KITITAS COUNTY
DEPARTMENT OF PUBLIC WORKS

MEMORANDUM

TO: Clay White, Planner II, Community Development Services
FROM: Joseph Sheridan, Development Review Technician 
THRU: Paul D. Bennett, P.E., Director of Public Works
DATE: June 17, 2004
SUBJECT: Shor Short Plat

SHOR SHORT PLAT

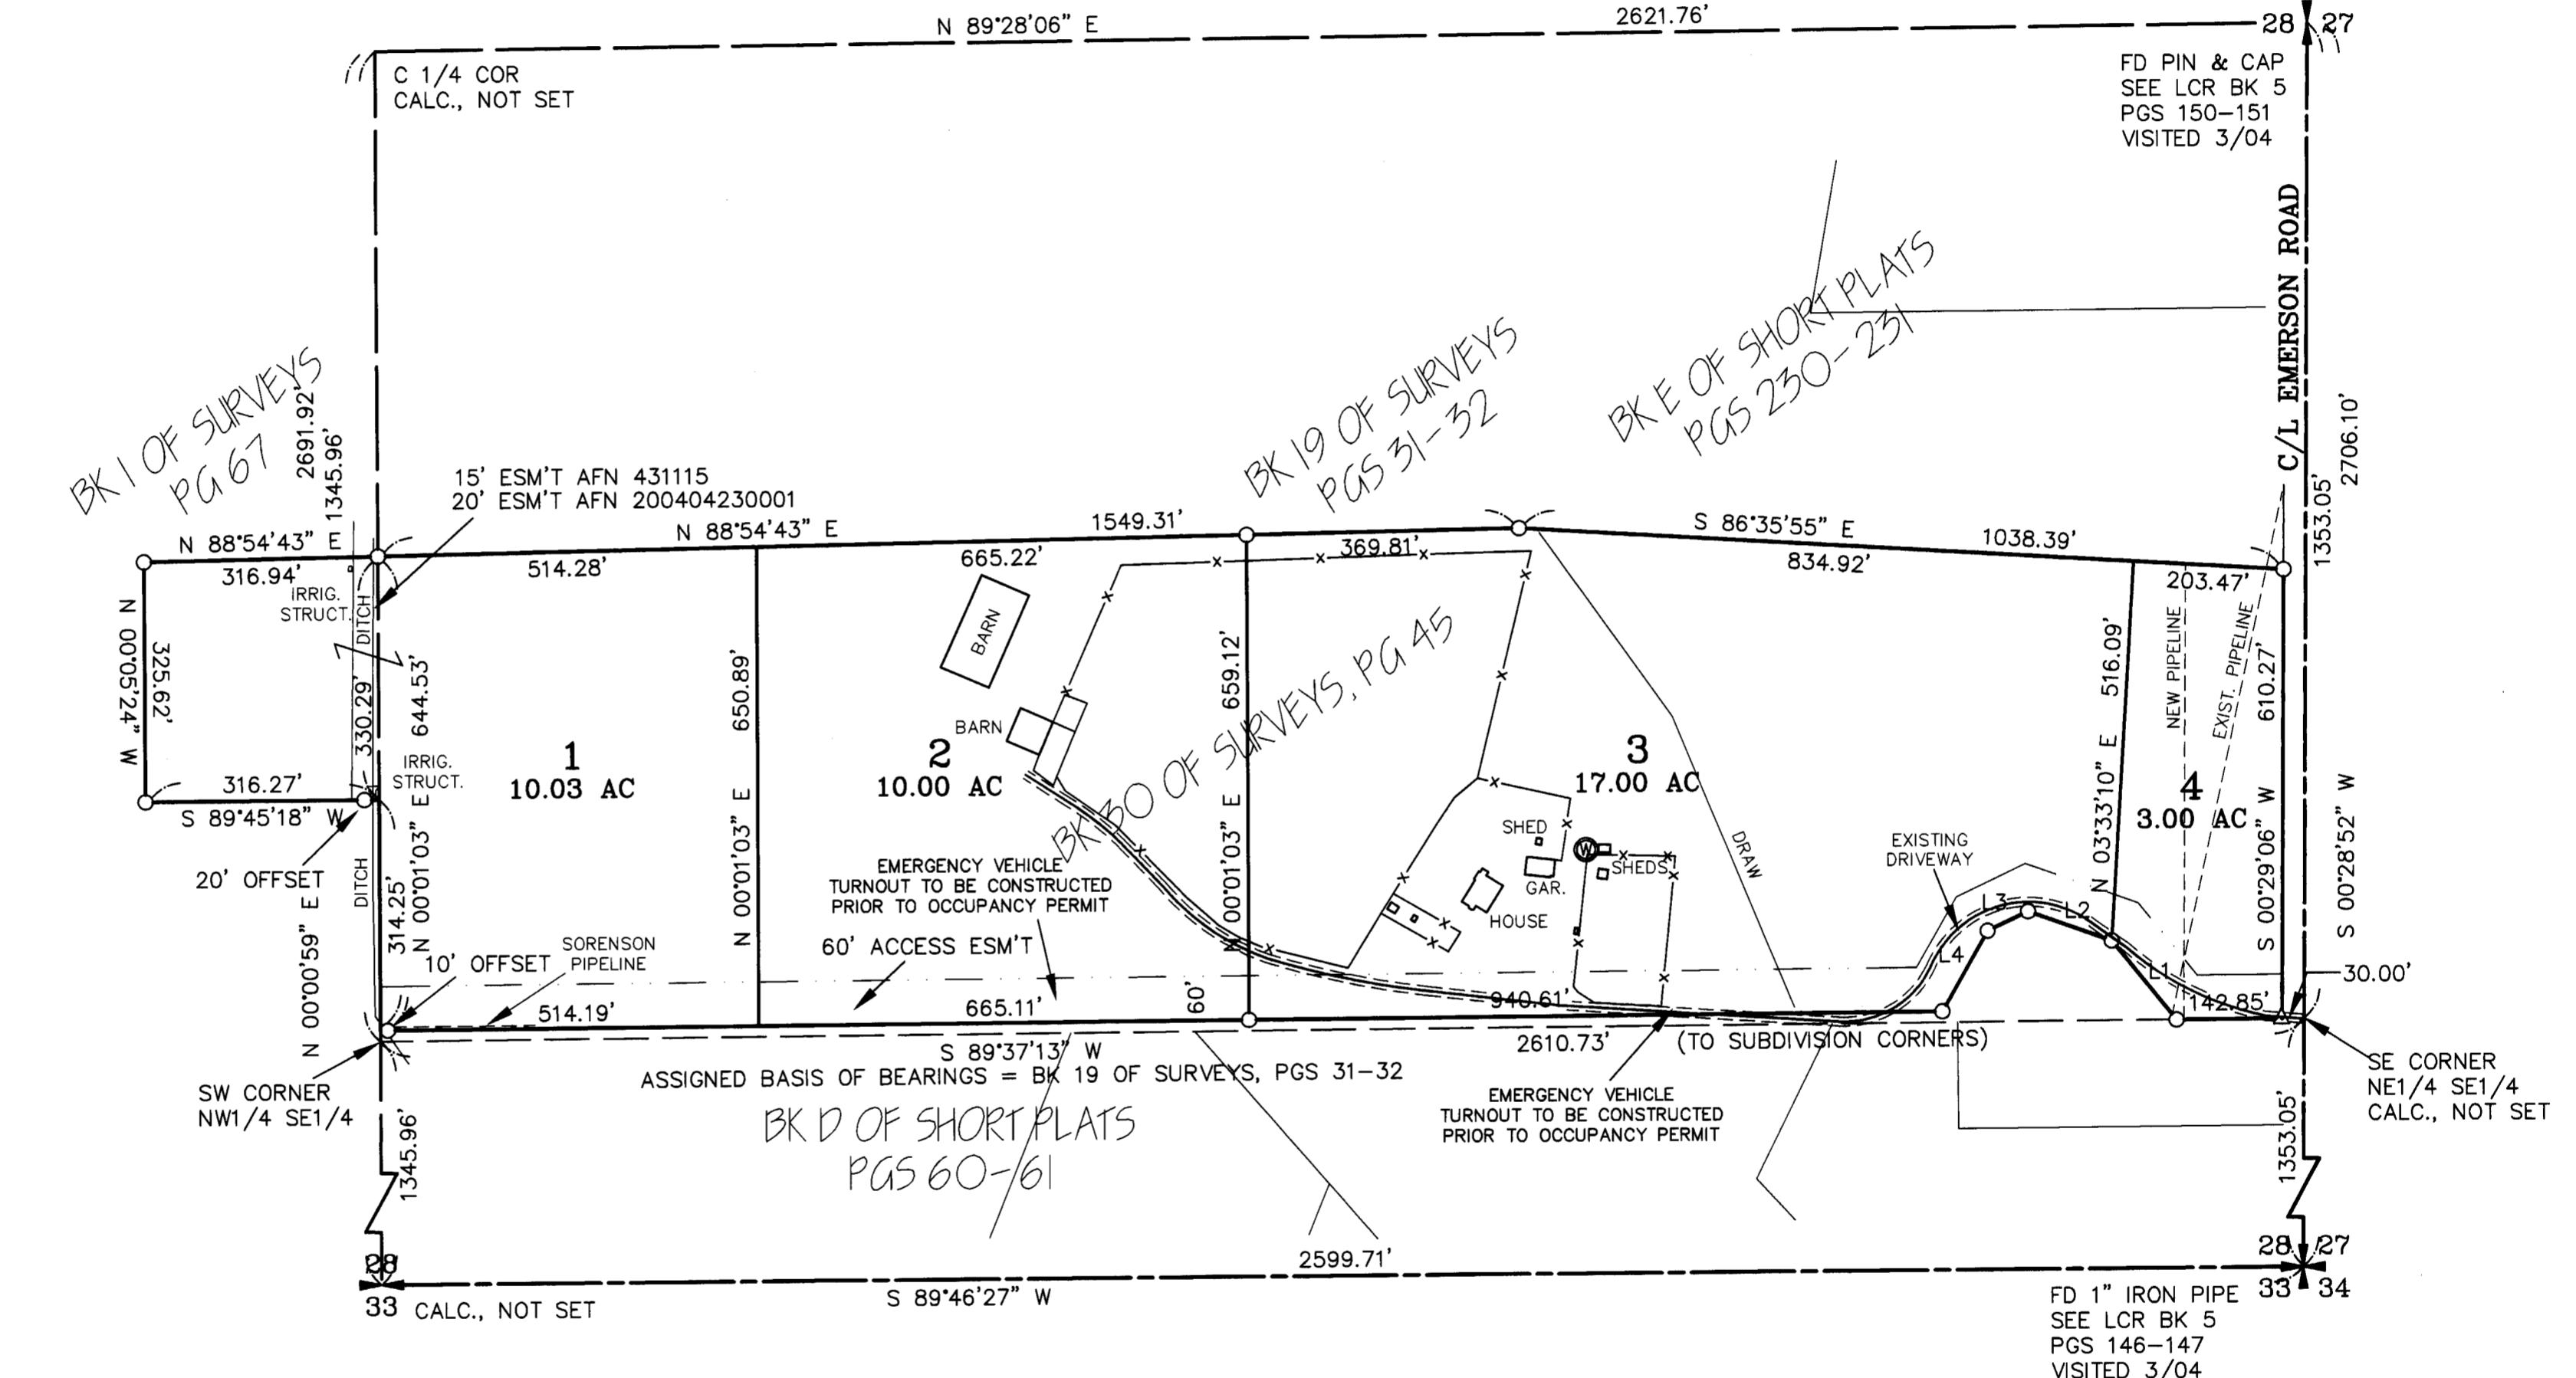
5. Fire Protection:
- a. Two Emergency Vehicle turnouts shall be constructed at approximately the half waypoints of both proposed Lots 2 and 3 or as otherwise instructed by the Kittitas County Fire Marshall.

6. Plat Notes: Plat notes shall reflect the following.
- a. Two turnouts shall be constructed at approximately the half waypoints of both proposed Lots 2 and 3 or as otherwise instructed by the Kittitas County Fire Marshall. **Update to face of Plat.**

- b. Lot 2, #1330 on the closure sheet calls out a distance of 665.11'. On the Plat called out 665.12'. Assuming rounding? **Update to face of Plat.**

- c. Total, #1316 on the closure sheet calls out a distance of 2119.92'. On the Plat called out 2610.73'? **Update to face of Plat.**
